City of Albuquerque Stormwater Construction Site Inspection Report

ESC File No.	B18E029	Project Name:	The Peaks by Markana Ph 2		
NPDES Id. No.	NMR1004QW	Location:	6700 Modesto Avenue NE		
6/29/2022	Owner	Contractor			
Operator	KLA 9, LLC.	Kasam Construction			
Contact name & title	Faizel Kassam	Stephen Pendergraft			
e-mail	fkassam@legacy-hospitality.com	Spendergraft@Legacydm.net			
Contact Phone #	505-489-4474	720-7188			
COA Inspector	Doug Hughes	Start/End Time:	2:00 AM		
Construction Phase:	Staging				
Type of Inspection:	Regular	Storm Event	Past Storm Event >0.25"	311/Complaint	Follow Up
Weather at time of inspection?	Clear		Temperature:	~	94
Estimated date of last storm 0.25" or greater	6/27/2022

TEMPORARY EROSION AND SEDIMENT CONTROL PLAN

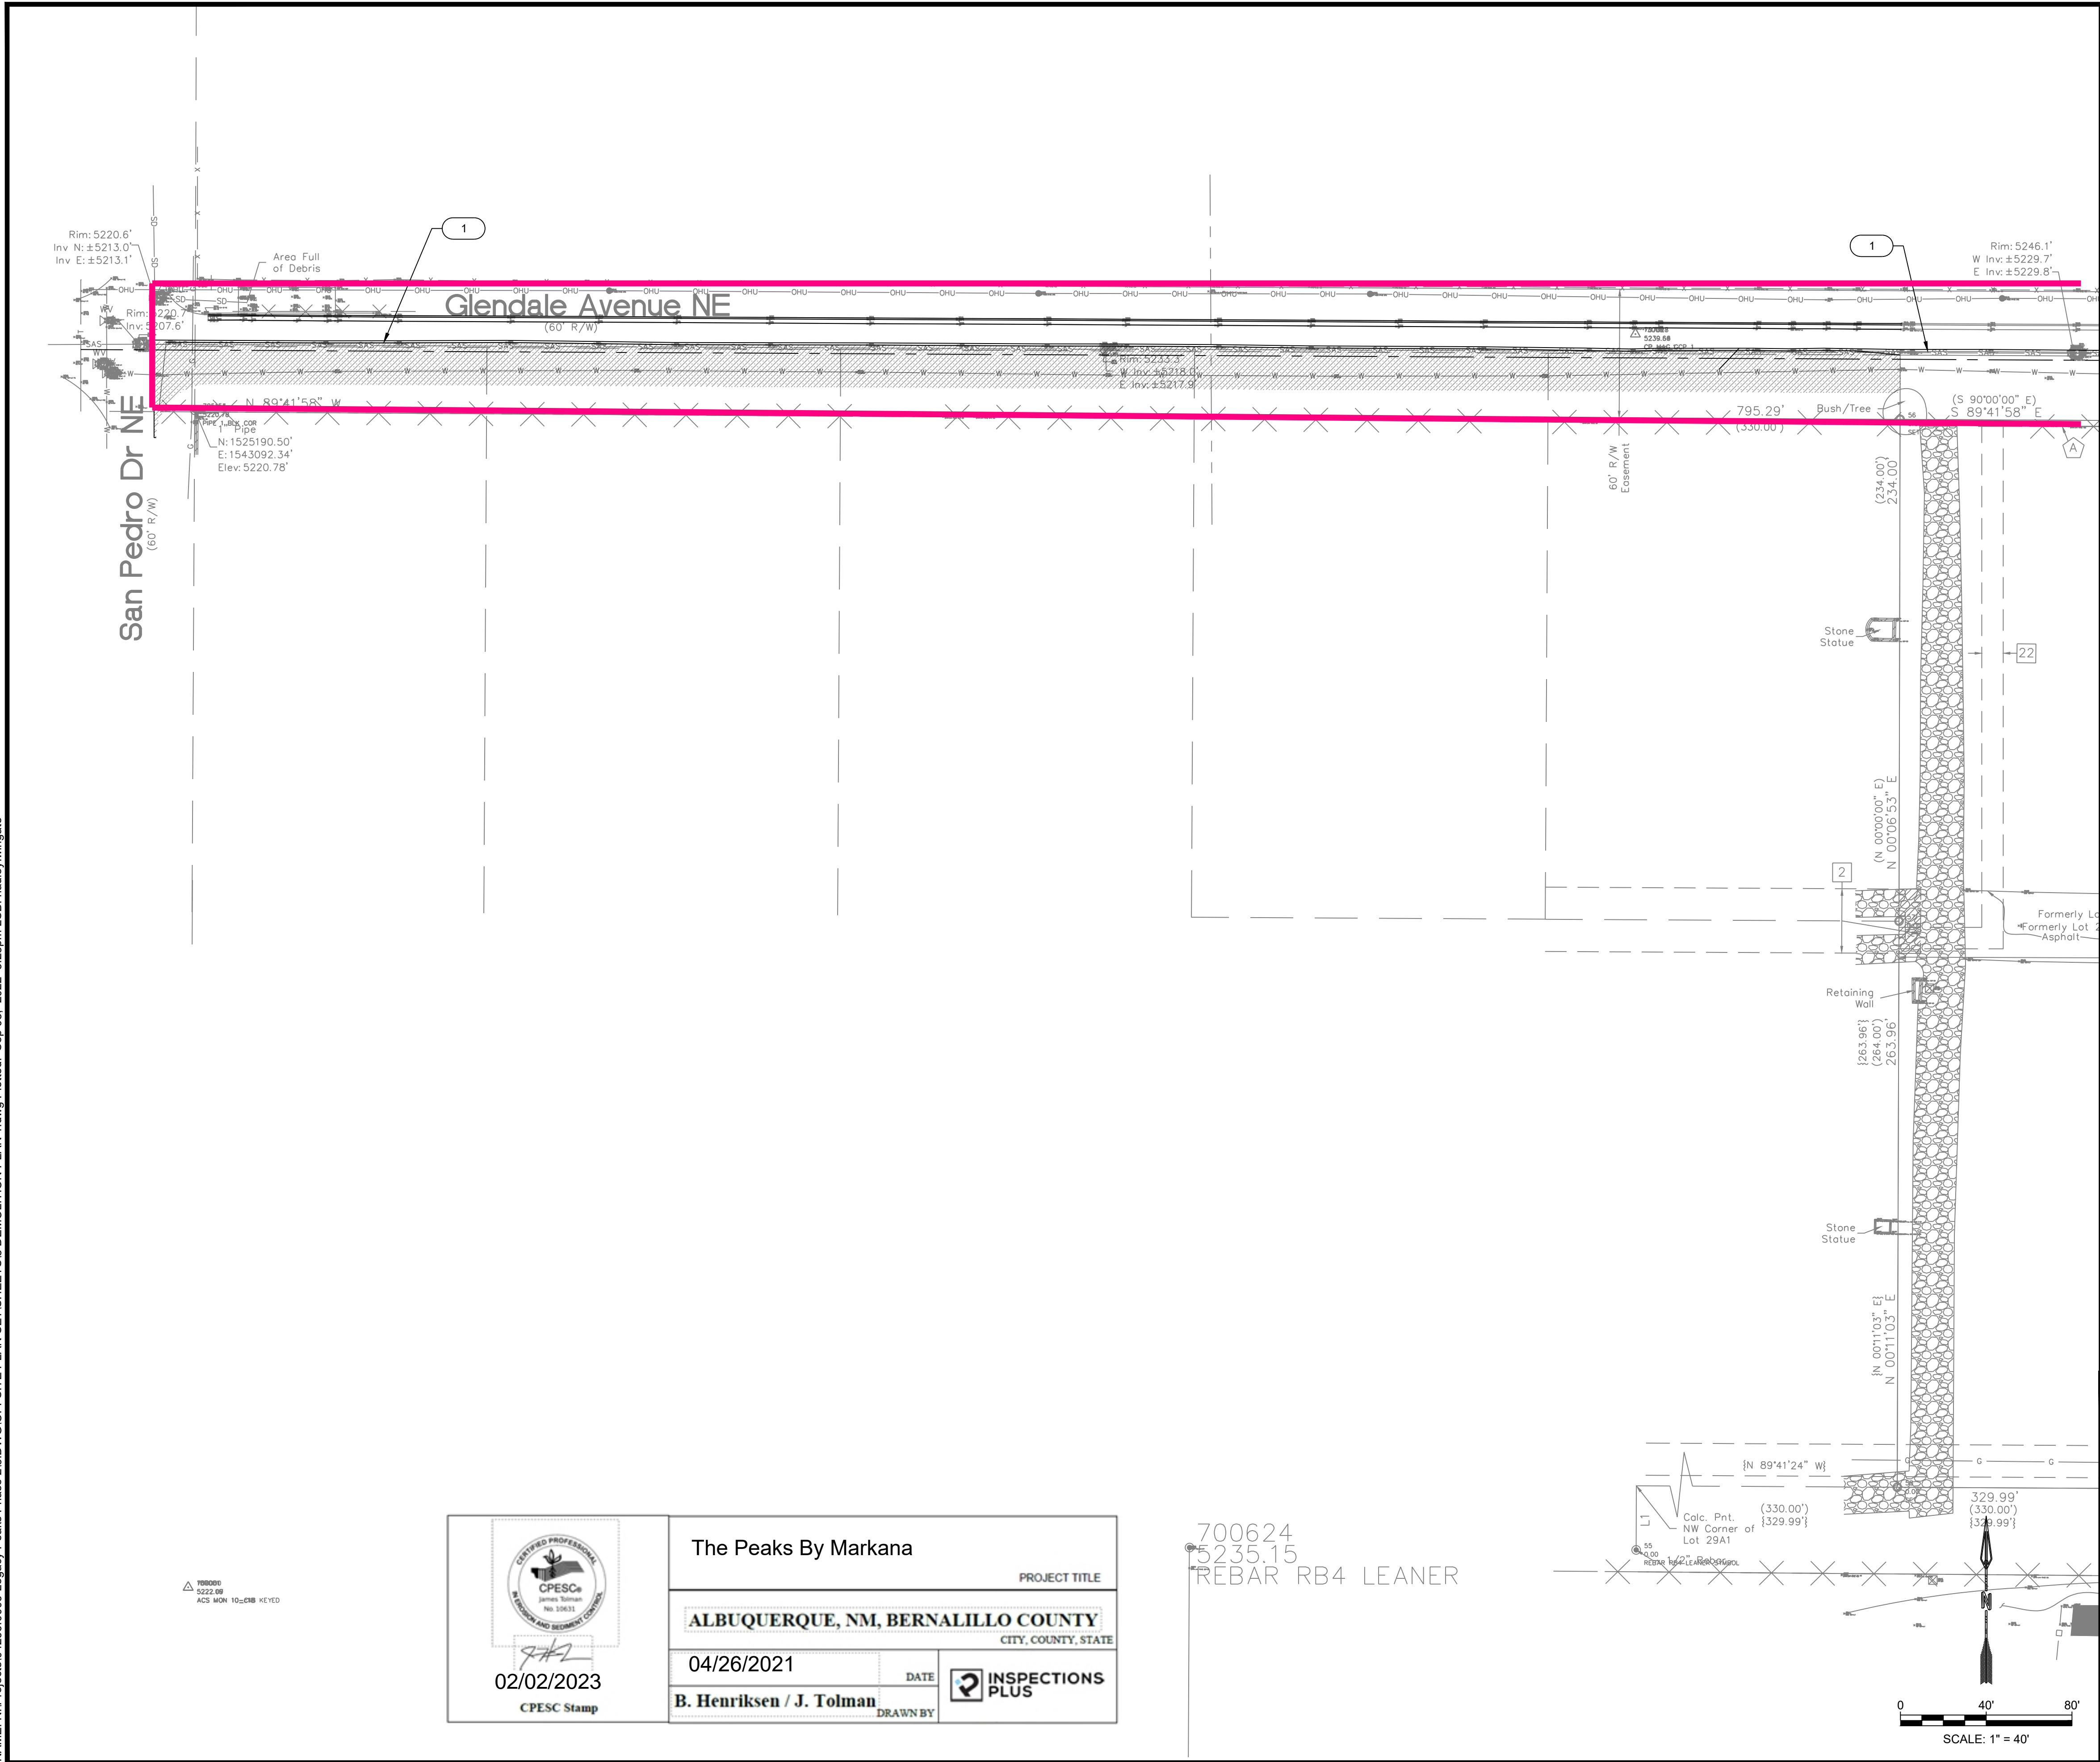
Item Number	Deficiency/ Corrective Action				
1	SWPPP was up-to-date and available, Posting was being put up by Stephen, BMP instalation was nearly complete. So previous violations were mitigated.				
2	The SWPPP map needs updated with current conditions showing mulch sock instead of silt fence, and area of disturbance south of site on City property. Also show the planned trail connection and easement to Phase 1 and add landscaping stabilization to offsite disturbed areas.				
3	Please provide a copy of the latest self-inspection report.				
4
